MIXED USE DEVELOPMENT (SSD 10251) 42 HONEYSUCKLE DRIVE NEWCASTLE

I refer to your letter of 9 July 2019 advising that a development application submitted by Doma Australia Holdings Pty Ltd for alterations and additions to an approved mixed-use development on the site was being publicly exhibited and inviting City of Newcastle (CN) to comment.

**GFA Plans**

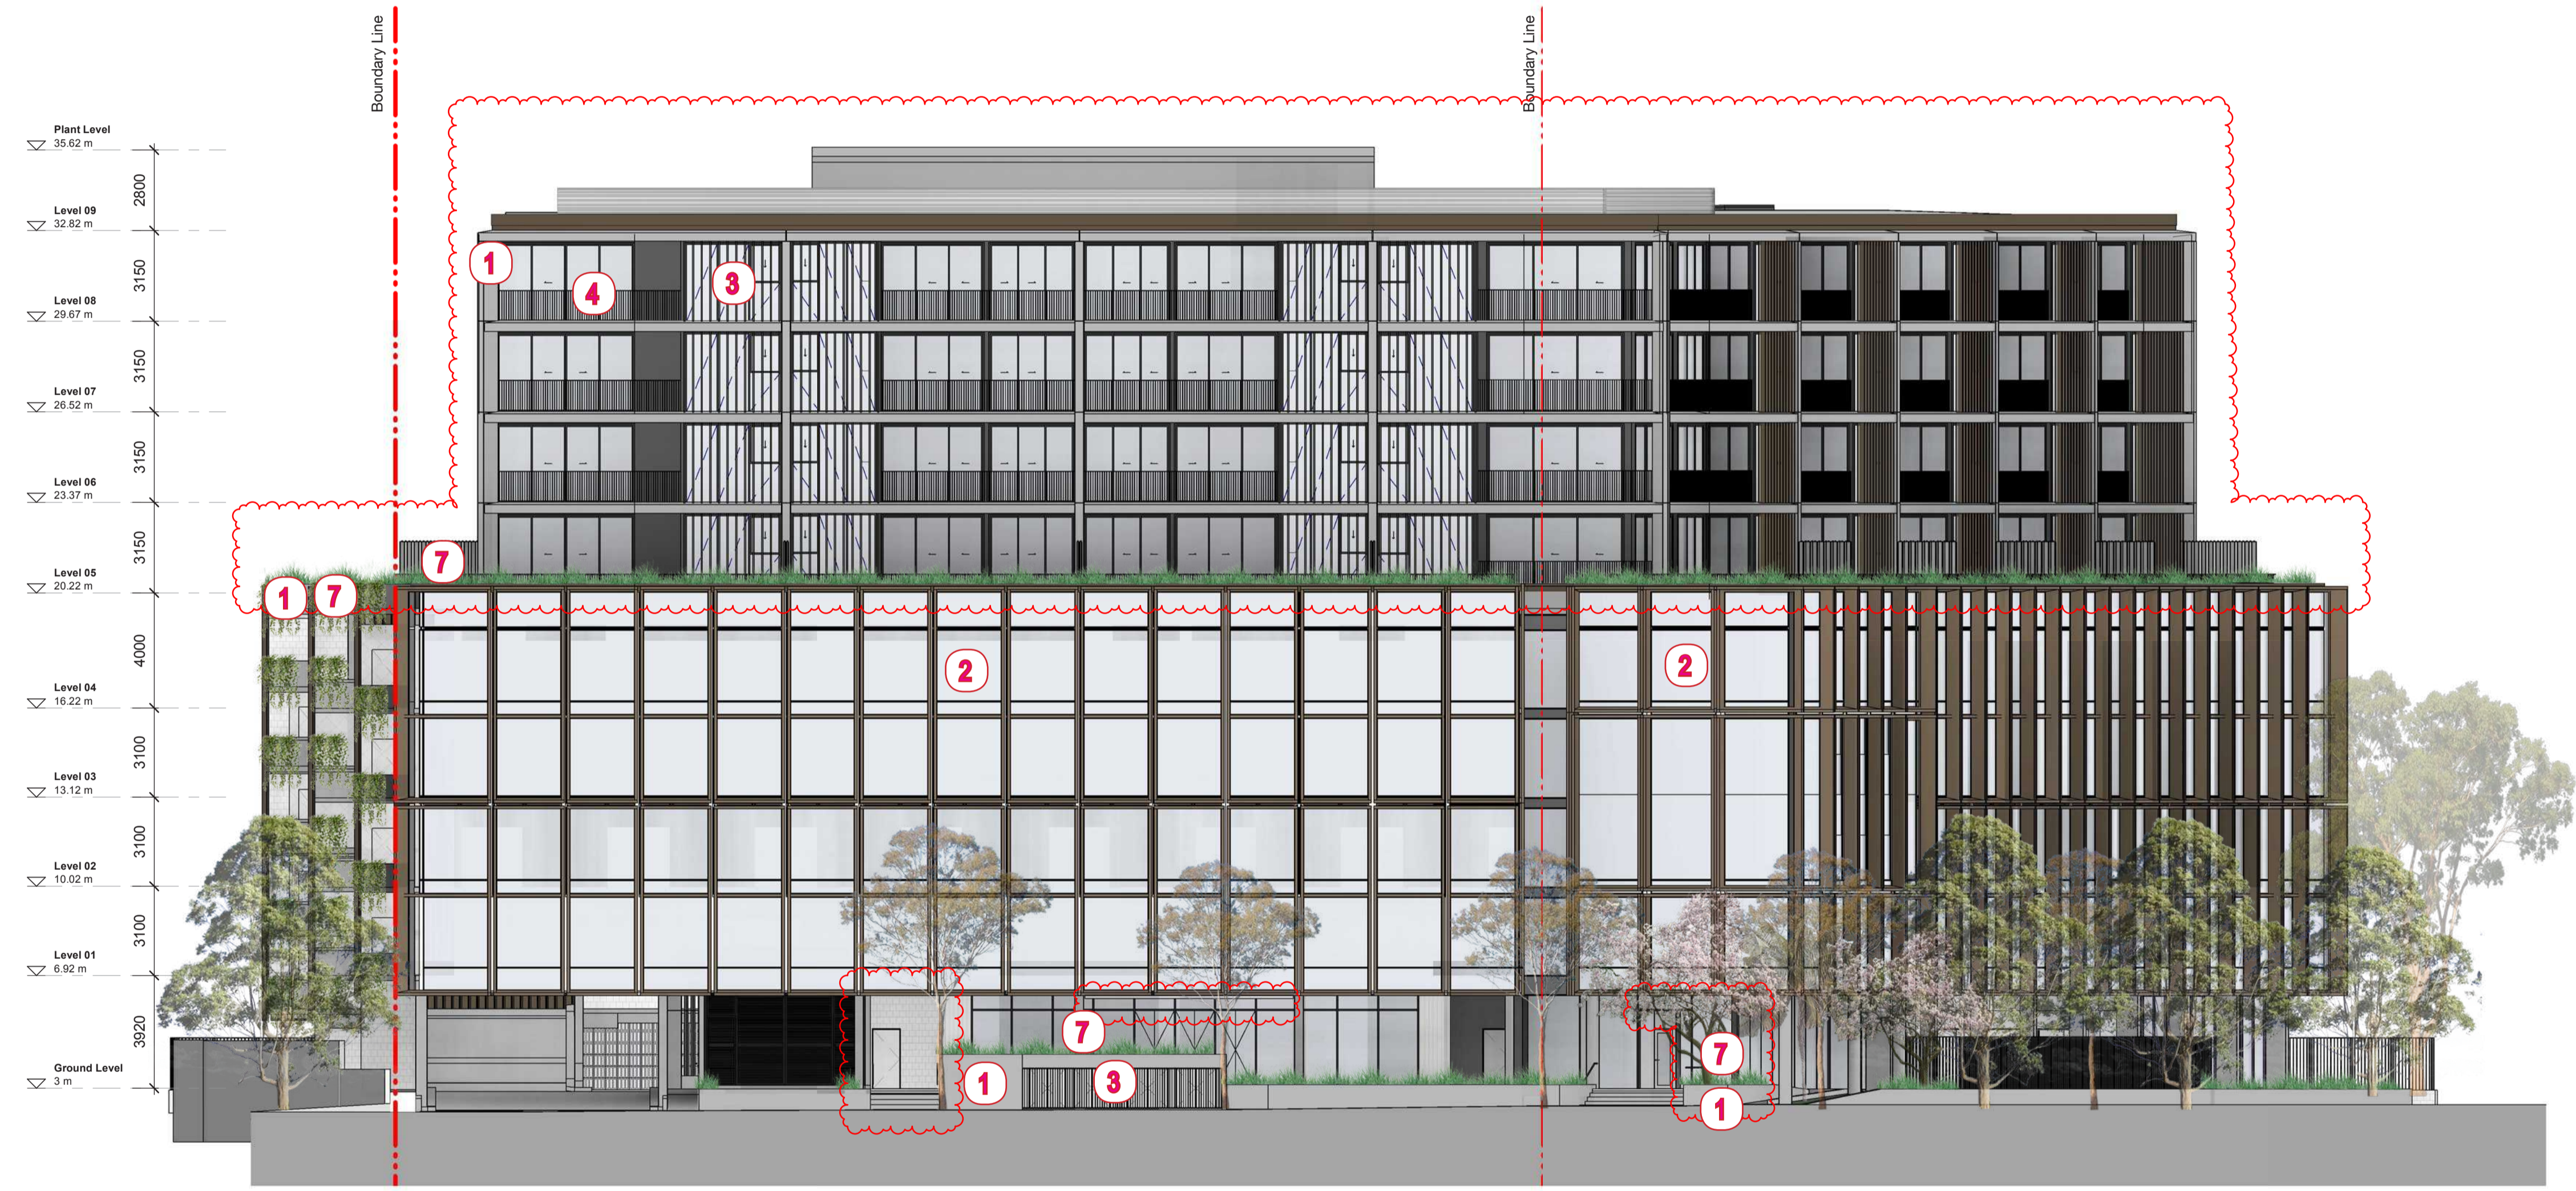
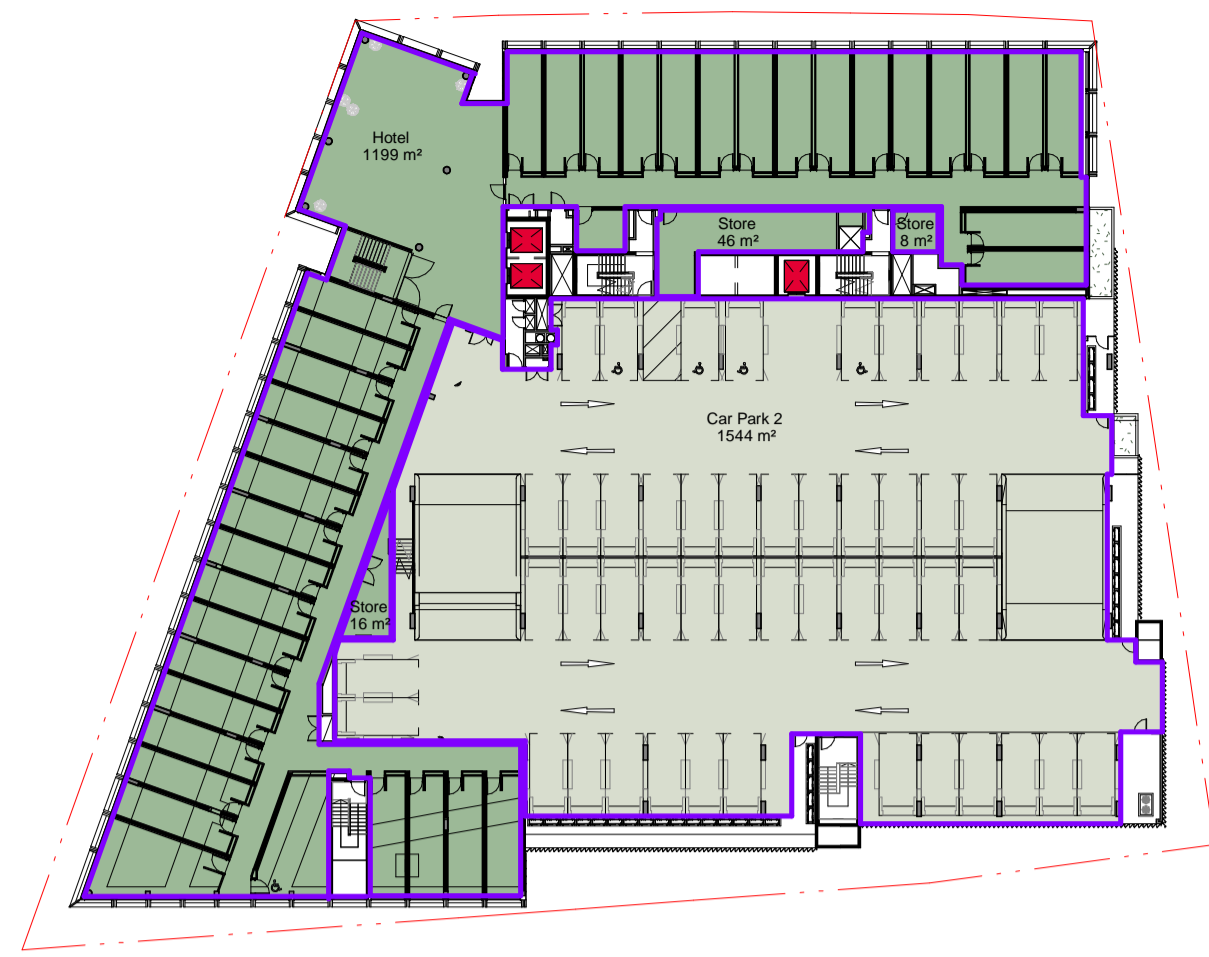
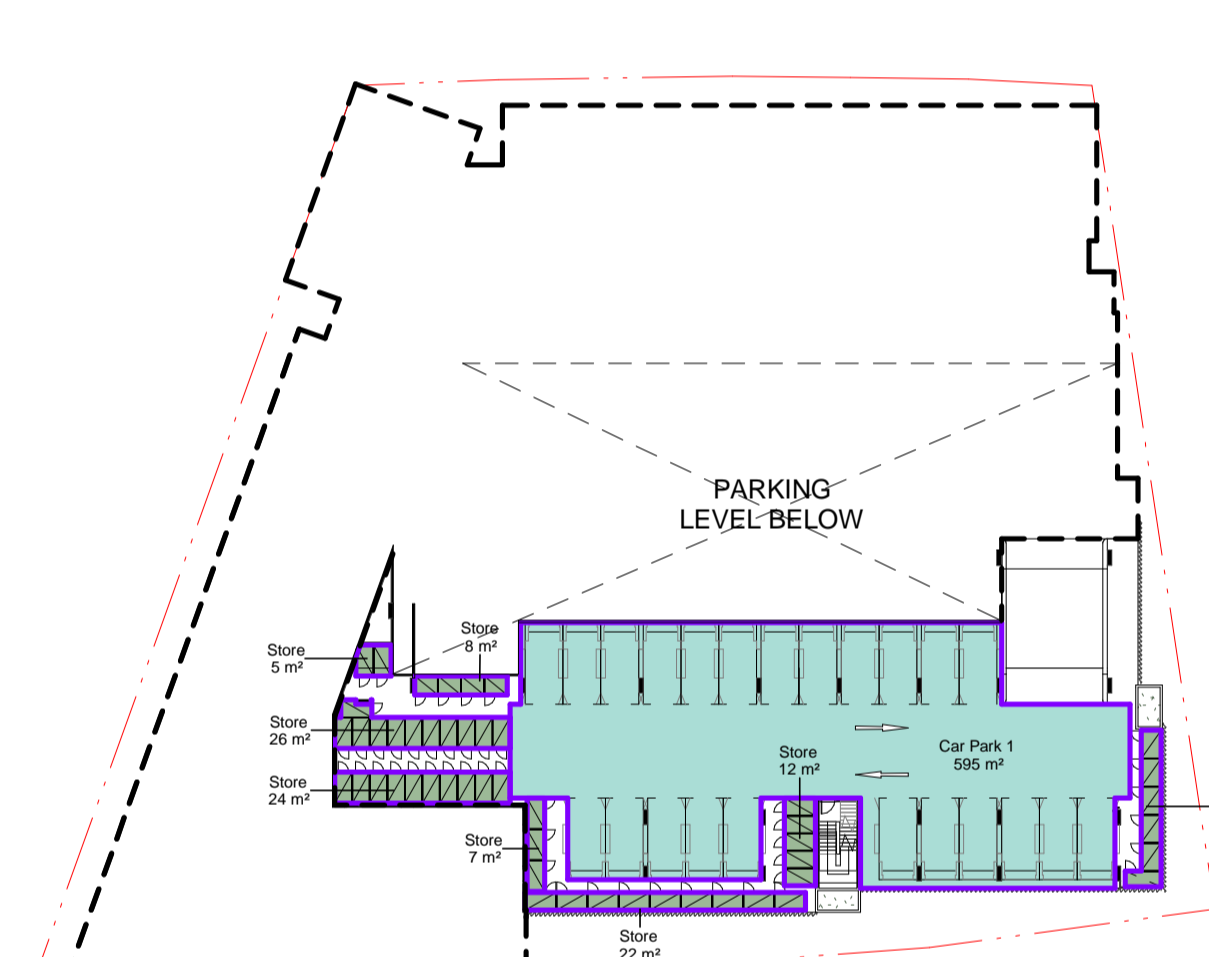
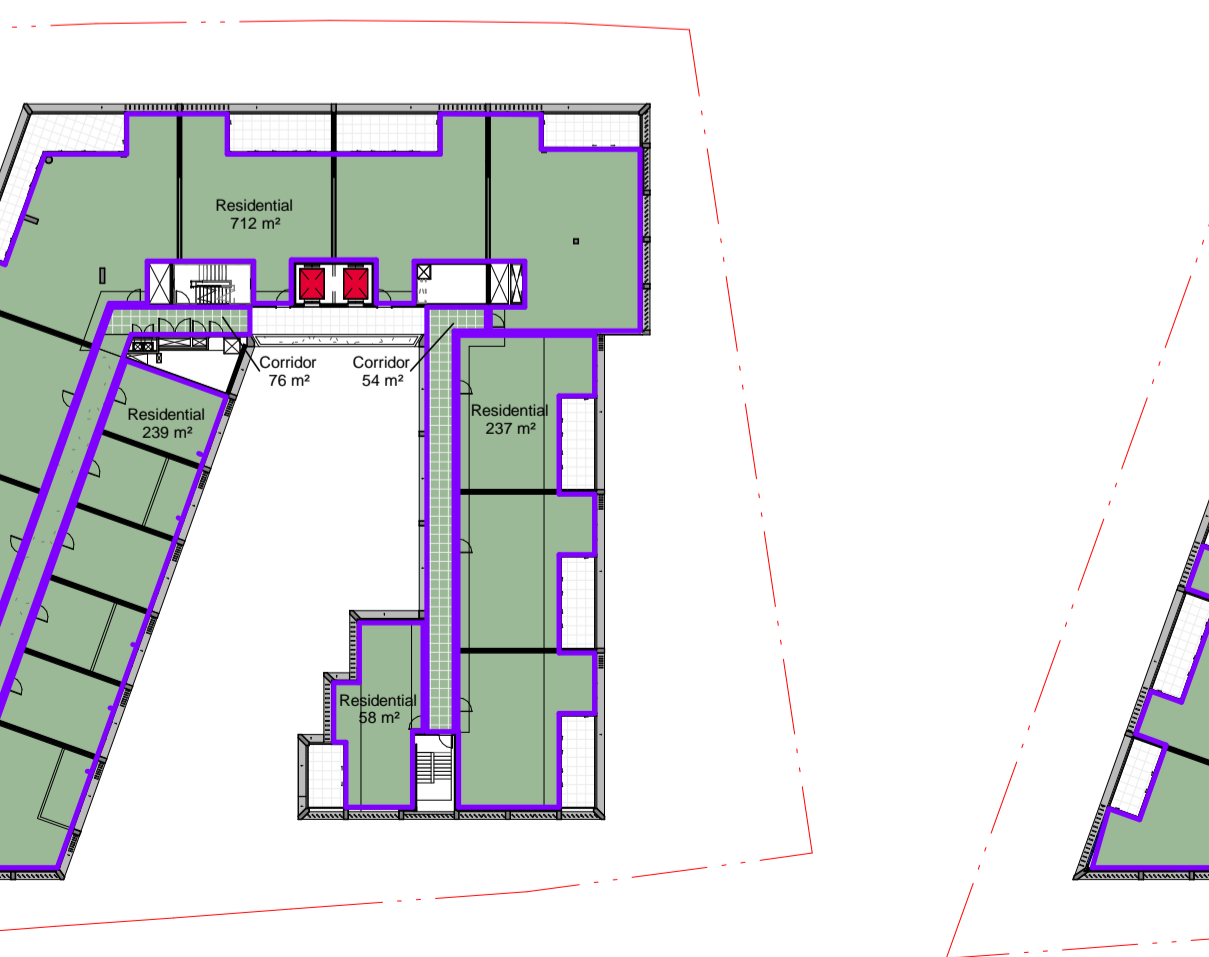
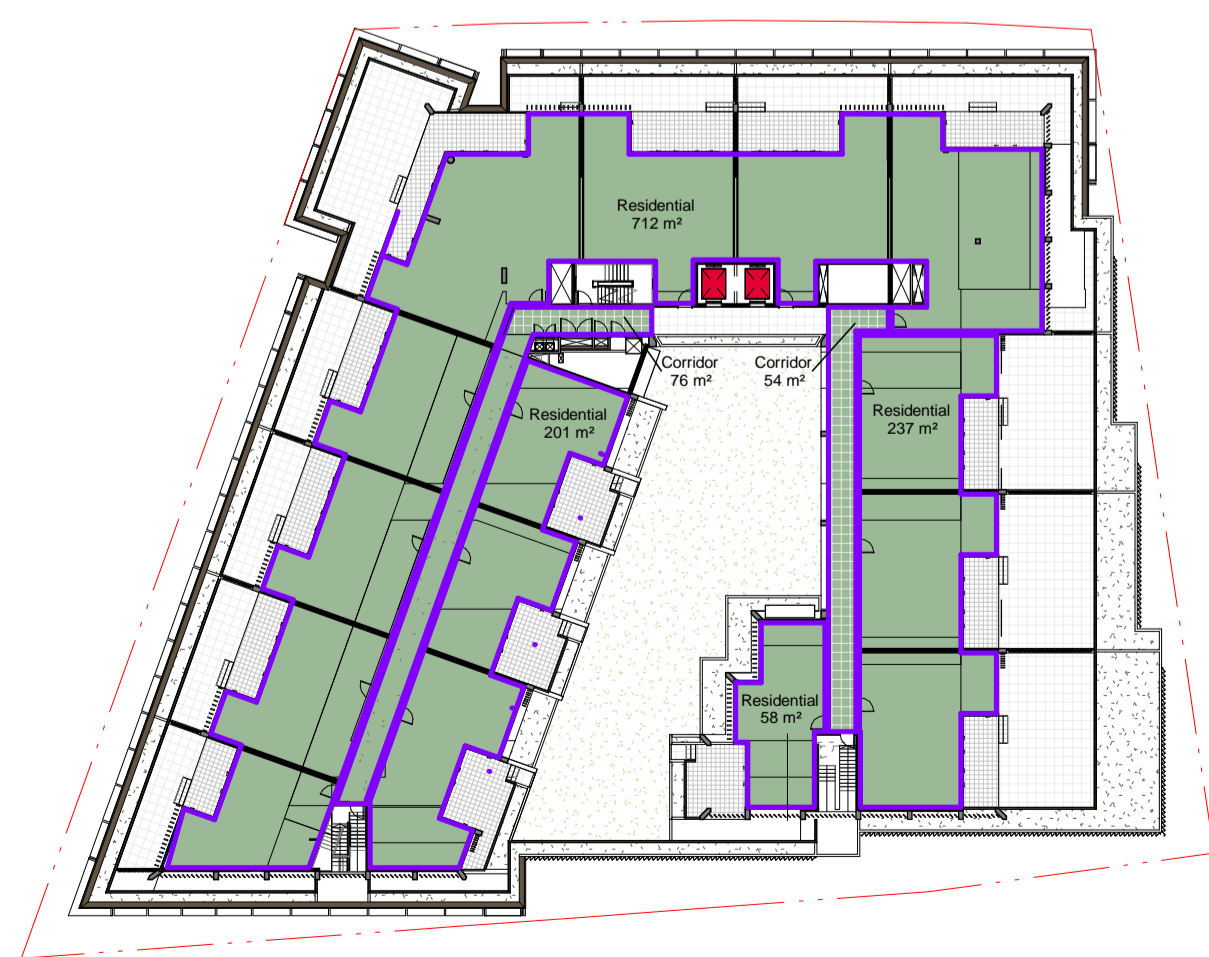
The EIS (Pg. 43) states that the proposed development has a Gross Floor Area of 11,250m² which equates to the allowable Floor Space Ratio (FSR) of 3:1 under the Newcastle Local Environmental Plan 2012 (NLEP). As demonstrated in the Traffic and Parking Assessment prepared by The Transport Planning Partnership (Appendix K of the

EIS) the development has 63 car parking spaces in excess of the Newcastle Development Control Plan 2012. Such spaces will comprise the public car park. The definition of Gross Floor Area under the NLEP provides that carparking in excess of any requirements of the consent authority is included in the GFA of the development. Examination of the submitted GFA plans and associated Area Schedule suggests that when the surplus parking is included the GFA of the development exceeds 11,250m² and therefore the allowable FSR.

Further clarification should be sought from the application regarding this matter.
